Phone: 0300 123 6780
Email: Kathryn.Walsh@lancashire.gov.uk
Your ref: 3/2025/0039
Our ref: 3/2025/0039/HDC/KW
Date: 19 March 2025

Location: Dilworth Cottage Ward Green Lane Longridge PR3 2ZL
Proposal: Proposed demolition of existing dwelling and erection of new two-storey detached dwelling with rooms in the roofspace. Installation of Air Source Heat Pump and Solar Panels.
Grid Ref: 362793 437734

Lancashire County Council acting as the Local Highway Authority has concerns regarding the proposal and does not consider that the application as submitted fully assesses the highway impact of the proposed development as set out in this response.

DRAWING TITLE
Location and Block Plan

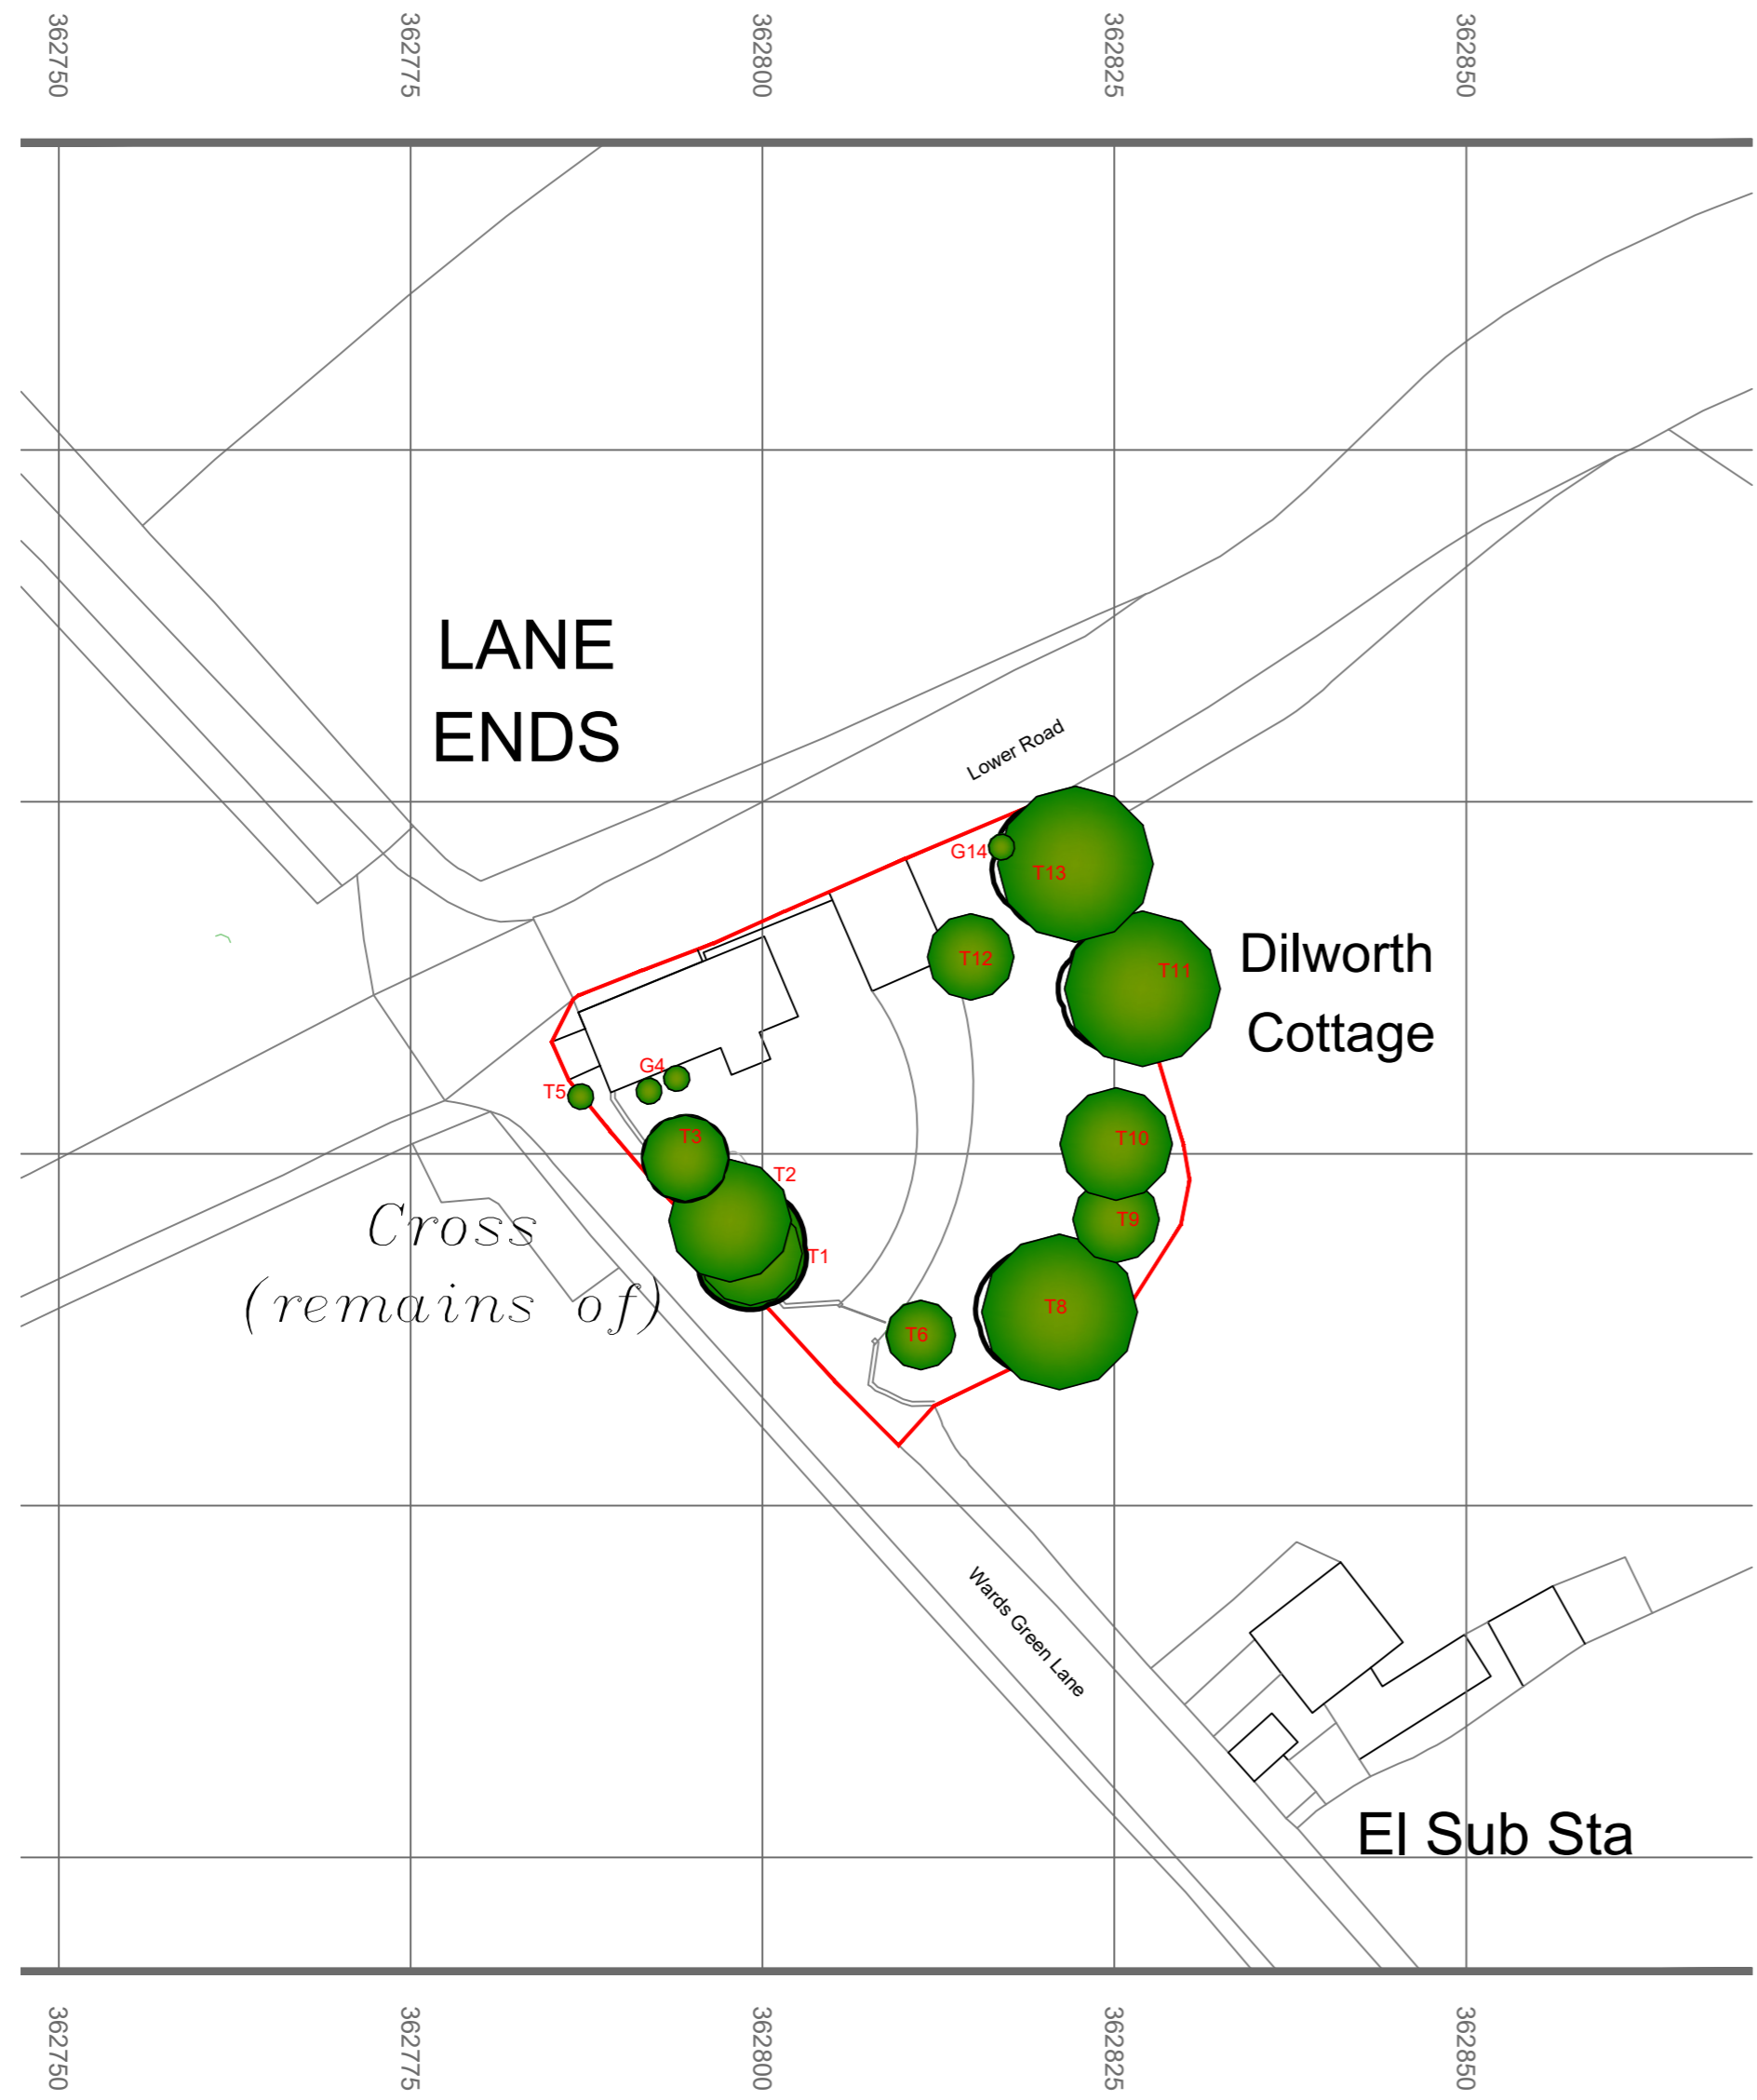
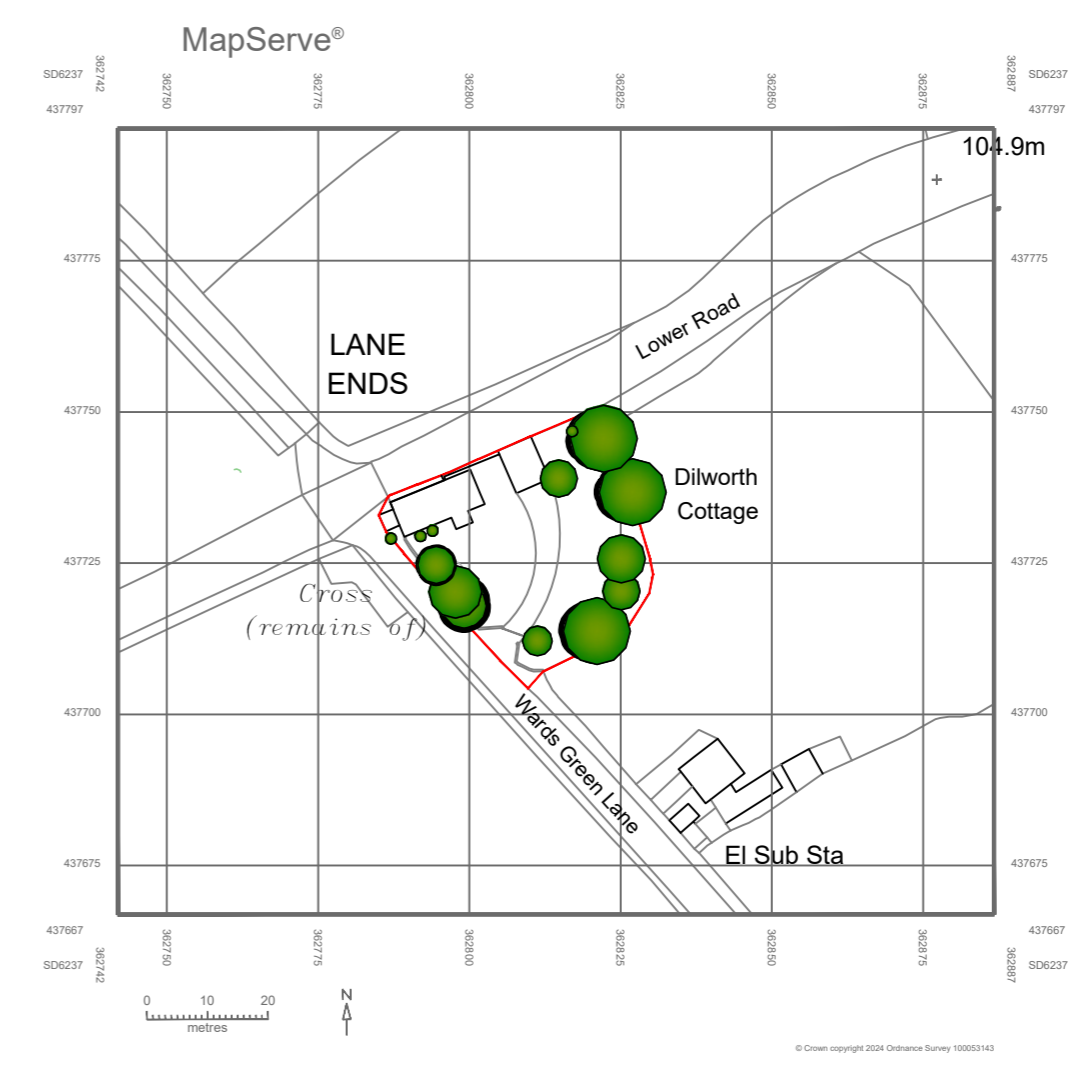
The existing dwelling currently sits fronting Lower Road and Wards Green Lane. Whilst the application makes note of improvement to the junction visibility within the design and access statement, given the location of the boundary wall, the LHA are of the view that there will be minimal improvement, this is due to the height of the wall that will be retained. The wall would benefit from being lowered to 0.9m. Existing and proposed visibility splays to the right at the junction of Lower Road and Wards Green Lane would allow the LHA to review any proposed improvements to the sight lines.

The existing house walls are currently retaining the highway as such no part of the development shall commence until a scheme for the retaining structure adjacent to the highway has been submitted to, and approved by, the Local Planning Authority in consultation with the Highway Authority.

In conclusion, Lancashire County Council, acting as the Local Highway Authority, has identified concerns related to highway safety. Improvements to junction visibility, particularly lowering the retaining wall would enhance sight lines, however a scheme for the retaining structure adjacent to the highway will be necessary to ensure compliance with safety requirements.
